Application Reference: 2026/0448

Site Address: 15 Wentworth Crescent, Penistone, Sheffield, S36 6ES

Introduction: This application seeks full planning permission for the removal of detached garage to side and erection of single storey rear extension, rear dormer and infill to front recess to dwelling.

Client Martin and Vicky
 Project 2657 : 15 Wentworth Crescent : Domestic Extension
 Title Existing and Proposed Elevations

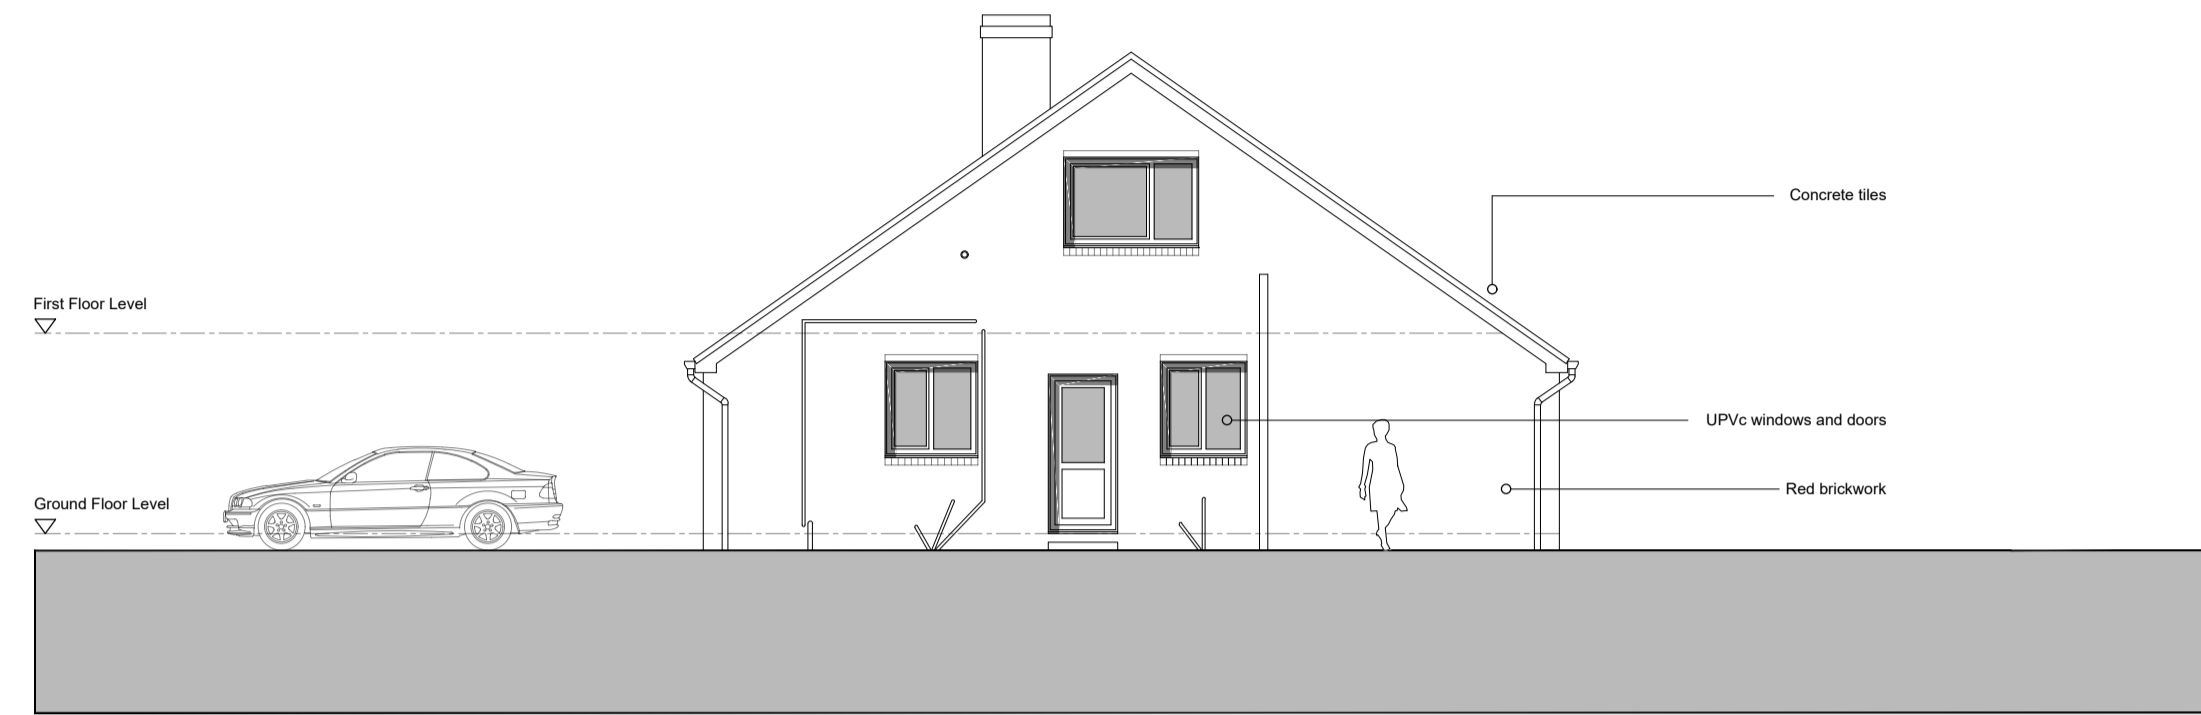
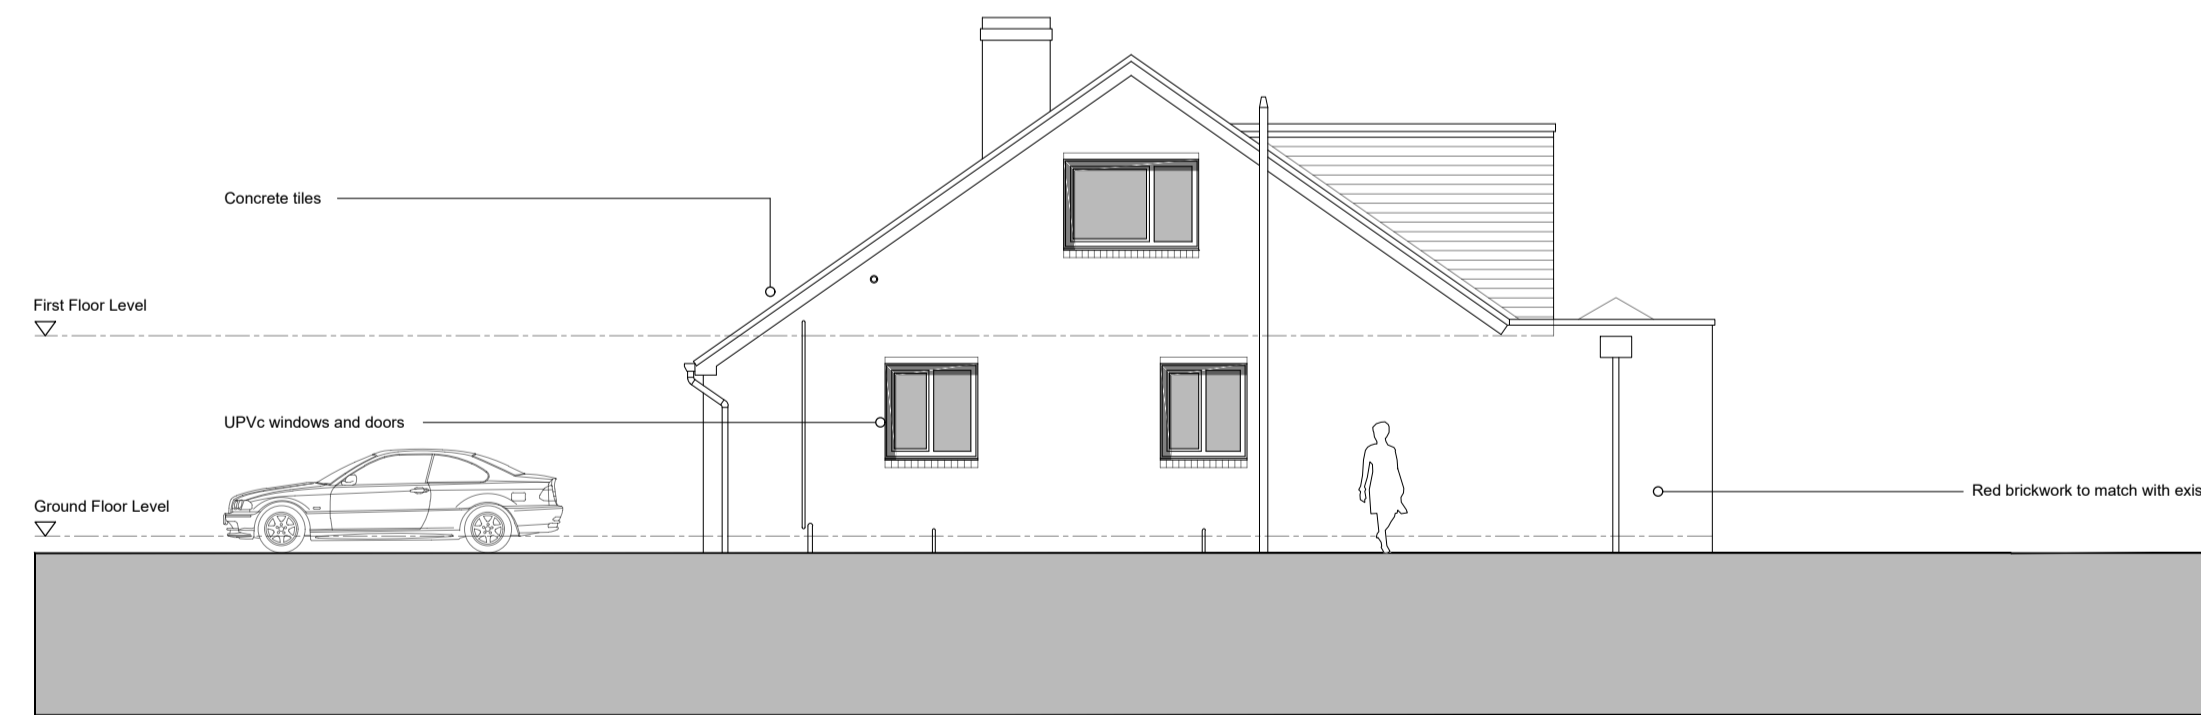
The approximate 2.3m rear projection of the proposed ground floor rear extension, which also practically extends across the whole width of the rear elevation, is less than the 3m usually allowed through permitted development. However, with an approximate flat roof height of 3.10m, which is also higher than the existing eaves height of approximately 2.64m, and with a roof lantern extending to about 3.38m, the proposal does not meet the height requirements for permitted development, with this type of roof. For a planning application, whilst the eaves should not usually be higher than the existing eaves, the main roof is also being altered, but not heightened, and it is the rear elevation, not the principal front elevation, so would not be as impactful within the street scene as if it was constructed on the front elevation.

The proposed addition of a relatively large rear dormer does not affect the height of the existing roof, which remains with a ridge height of approximately 6.8m. Like the rear extension, the size of the proposed dormer at approximately 36 cubic meters, may have been eligible for permitted development. It would again though be the modified eaves height of the dwelling, and potentially the proposed composite cladding not being of a significant enough similar appearance to the materials used within the existing house which would disqualify the proposed dormer as eligible for permitted development.

Whilst the scale of the proposed rear extension and dormer, are both acceptable, the design of the dormer is not strictly in accordance with SPD guidance. For dormers which require planning consent, the SPD House Extensions and Other Domestic Extensions states a preference for pitched roof dormers, constructed with hanging tiles to match the roof. For this application, the proposal is for a box dormer featuring grey composite cladding. Whilst in essence this differs from SPD guidance, box shaped dormers are prominent features on bungalows across the borough, and increasingly are constructed with composite cladding, also frequently grey in colour. Whilst it is uncertain if bungalows within the street scene have rear box dormers, an adjacent, almost identical bungalow sitting below the application dwelling on Hall Gate, along with another detached bungalow on Hall Gate feature rear elevation box shaped dormers.

The proposed infill within the front elevation of the dwelling, along with relocation of the principal entrance door onto the front elevation would potentially provide the most significant change to the design and character of the dwelling. If the front door had already existed on the front elevation, then the infill, at less than 3 sqm, may have qualified as permitted development. Whilst the proposal does potentially improve the design of the application dwelling, the counter effect of unbalancing the symmetry of the pair of semi-detached bungalows and the combined trio of similarly designed pairs of bungalows on the street must be considered.
